Appeal Decision

Appeal Ref: APP/R5510/D/22/3290030

21 Tiverton Road, Ruislip, HA4 0BW

- The appeal is made under section 78 of the Town and Country Planning Act 1990 against a refusal to grant planning permission.
- The appeal is made by Mr & Mrs Quy against the decision of London Borough of Hillingdon Council.
- The application Ref 73915/APP/2021/3221, dated 23 August 2021, was refused by notice dated 18 October 2021.
- The development proposed is 2 storey side extension involving the demolition of an existing garage.

FRONT ELEVATION PROPOSED
SCALE 1:100

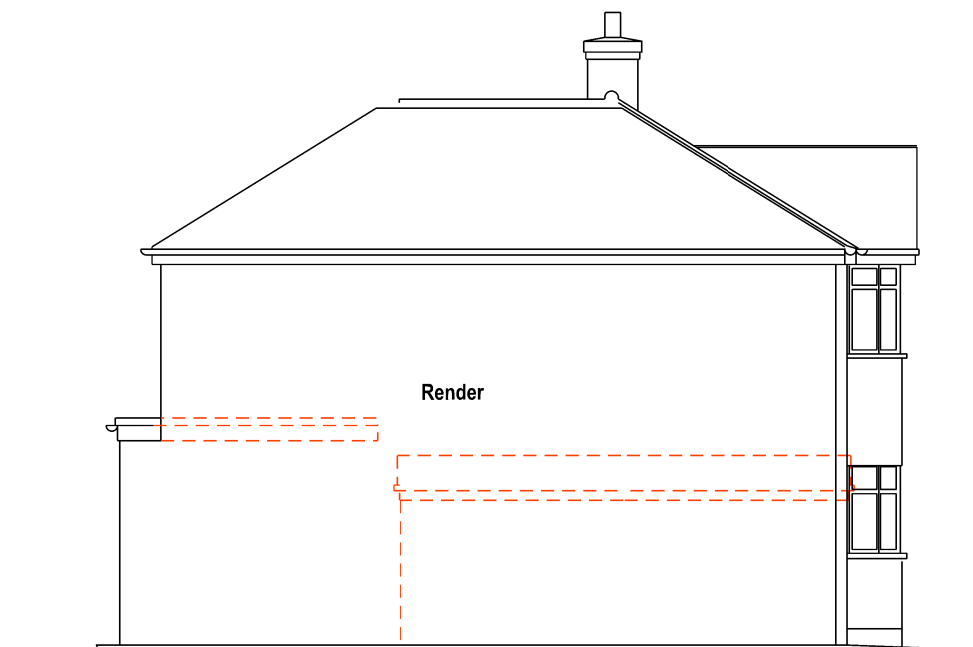
5. Having said that, in this case, I can see that the design of the proposed roof is intended to recreate the original hipped roof. As a consequence of extending from a roof that has been altered into a gable end, it would create a roof format that appears disjointed and out of character with the main roof. This would be further emphasized by the proposed step in ridge height. From the

front and side elevation, this distinctive lack of integration would harm the character of the host dwelling.

ROOF PLAN PROPOSED
SCALE 1:100

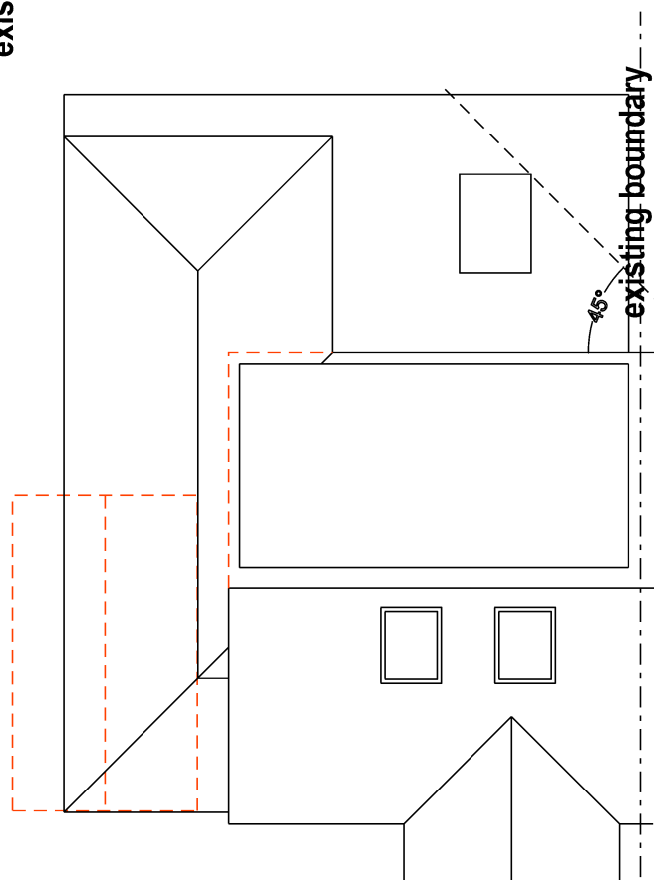
6. There may be other hipped roof extensions visible within the local area. However, these cannot be compared to the situation before me. The addition of this style of roof attached to the current roof would not respect the character of the dwelling. Irrespective of whether or not the local residents or other Council departments have raised no objections, it would appear as a visually intrusive feature that would harm the character and appearance of the terrace and the street scene.
7. To conclude on this main issue, given the design would not respect the characteristics of the dwelling or represent good design, I therefore find that the proposal would not meet the design expectations of Policy BE1 of the Hillingdon Local Plan: Part One - Strategic Policies 2012 and Policies DMHB 11, DMHB 12 and DMHD 1 of the Hillingdon Local Plan: Part Two - Development Management Policies 2020.

SITE BLOCK PLAN
SCALE 1:200

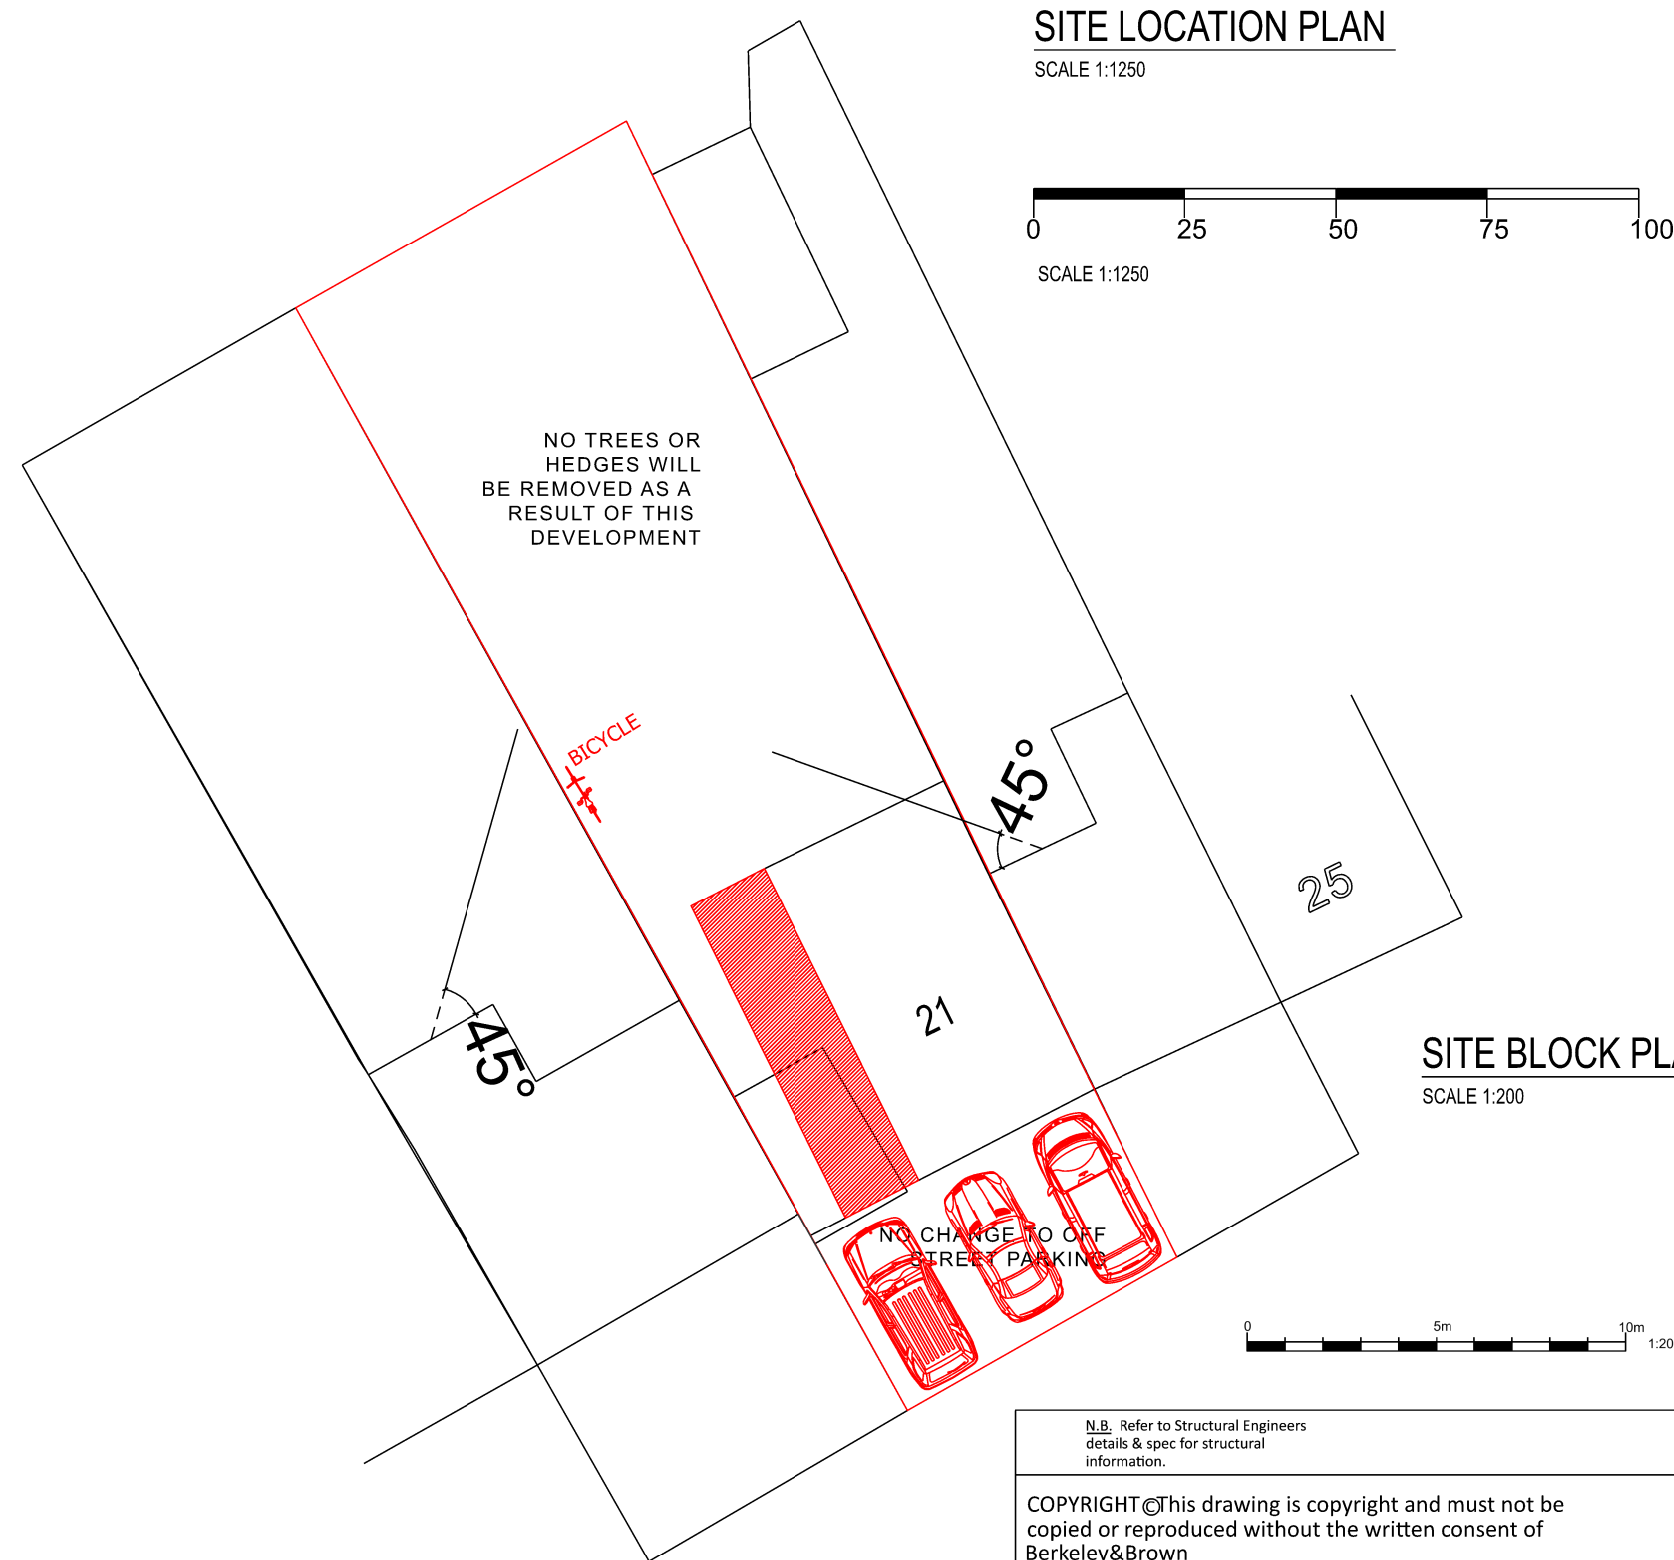
8. The proposed two storey extension would extend close to the shared boundary with 19 Tiverton Road. This dwelling has an attached garage located between the side of the dwelling and the shared boundary with the appeal property. The dwelling has a small rear extension that extends over more than half the width of the original house with a reasonable gap to the shared boundary with the appeal property. The paved patio area extends the full width of the plot and is a moderately sized space. The outlook from rear of the dwelling and garden is open in character onto a generously sized garden space.

9. Even though a two-storey extension is proposed, and it would project close to the party boundary by in-filling most of the side gap, given the position of the existing garage of the adjacent neighbour, this provides a standoff to the main house. I appreciate the extension would project further along the party boundary than their rear garage wall, and would be seen from rear windows. However, this would be at a separation distance from these windows that would ensure the extension would not appear as excessive development thus compromising their outlook. The outlook from Number 19 would otherwise remain open in character. All things considered, the projection would not result in a sense of enclosure or feeling of overbearing development from rear habitable room windows. In addition, it would not harm the outlook from these windows.

10. It would be visible from the neighbour's patio area although this space is wide, and again provides an open outlook. The proposal would not lead to visual intrusion when seen from this space or the remainder of the external garden space.
